8.3 Statement of Common Ground with Historic England

A12 Chelmsford to A120 widening scheme

STATEMENT OF COMMON GROUND

This Statement of Common Ground has been prepared and agreed by (1) National Highways Company Limited and (2) Historic England.

VIEWPOINT 20: Representative view north of PRoW 128_22, and Easthorpe Green Farmhouse (grade II listed)

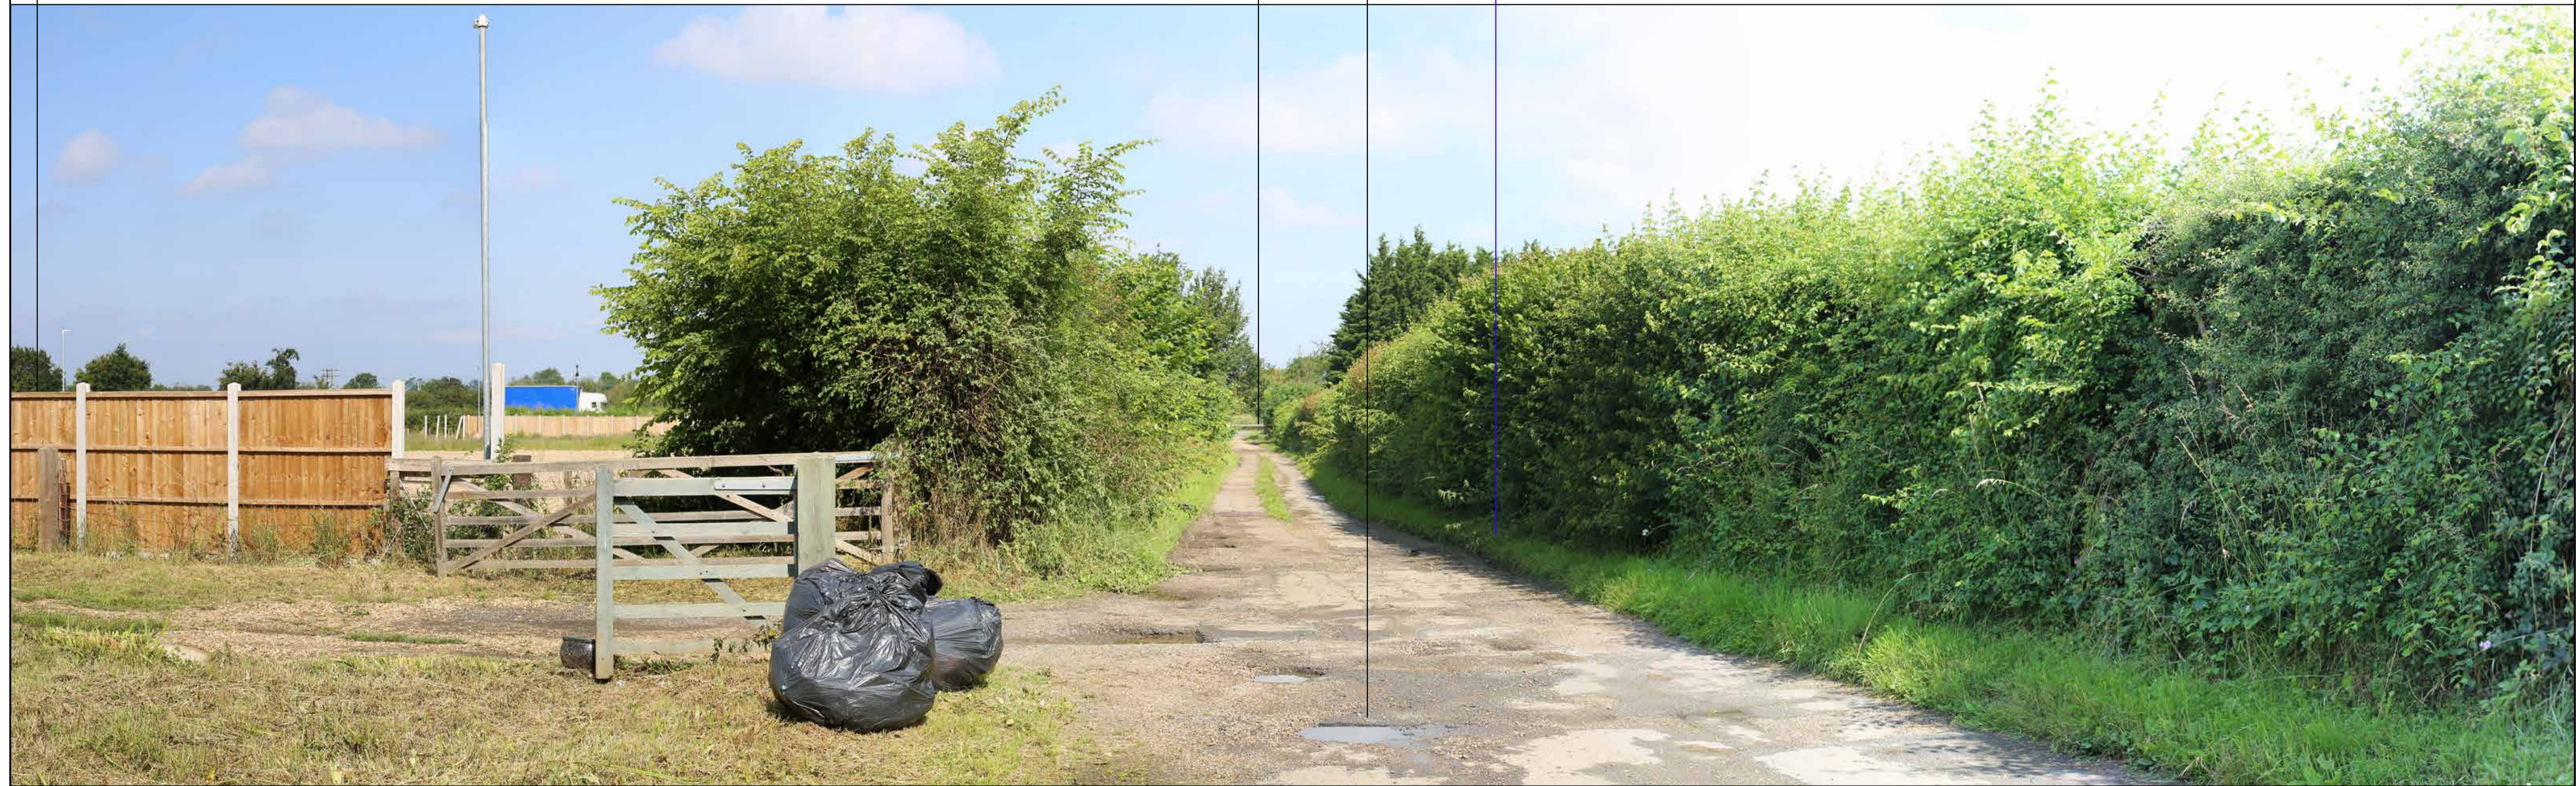
2.2	Impacts on designated cultural heritage assets	APP-6.1	There are concerns about the impacts of the route between junction 24 (Kelvedon North interchange) and junction 25 (Marks Tey interchange). The proposed bypass would impact the grade II listed buildings at Easthorpe Green Farm (Easthorpe Green	A detailed assessment of visual effects on receptors from representative viewpoints, which includes these	Agreed	26/5/2023

Ref.	Issue	Document Reference	Historic England Position	National Highways Position	Status	Date
			Farmhouse and Church View/Flispes). There would also be impacts on the grade II* listed barn at Marks Tey Hall. Associations with historic Easthorpe Green and Potts Green, which form their settings, require detailed assessment in the Environmental Statement. The Environmental Statement should clearly cross-reference to the baseline landscape chapter data. The landscape and visual assessment should include heritage specific viewpoints (photographs, photomontages and wirelines) to illustrate and support the results of the heritage assessment. Setting impacts on heritage assets should not be restricted to visual impacts and should include other factors during construction and operation. The assessment of impacts and mitigation provided for the assets described above is accepted. Consultation on the impacts and proposed mitigation for the scheduled Neolithic long mortuary enclosure at Appleford Farm, Rivenhall End (Asset 399) and medieval moat at Marks Tey Hall (Asset 818), and grade II* listed barn at Marks Tey Hall (Asset 816) is ongoing.	heritage assets, is presented in Appendix 8.3: Visual Effects Schedule, of the Environmental Statement [APP-6.3], which supports Chapter 8: Landscape and visual [APP-6.1], and was undertaken in accordance with DMRB LA 107 (Highways England, 2020). Historic England has also been consulted on these representative viewpoints. Appropriate mitigation measures in accordance with DMRB LA 106 (Highways England, 2020) have been developed and included in Section 7.10 of Chapter 7: Cultural Heritage [APP-6.1] and Appendix 7.9: Cultural Heritage Impact Summary Tables of the

Ref.	Issue	Document Reference	Historic England Position	National Highways Position	Status	Date
				Environmental Statement [APP-6.3].		
				Impacts from other aspects such as noise and groundwater have also been taken into account in Section 7.11 of Chapter 7: Cultural Heritage of the Environmental Statement [APP-6.1].		
				Historic England's concerns regarding impacts on the settings of the scheduled Neolithic long mortuary enclosure at Appleford Farm, Rivenhall End (Asset 399) and medieval moat at Marks Tey Hall (Asset 818), and grade II* listed barn at Marks Tey Hall (Asset 816) are addressed below at Ref. 2.6.		
				The Applicant has responded to Historic
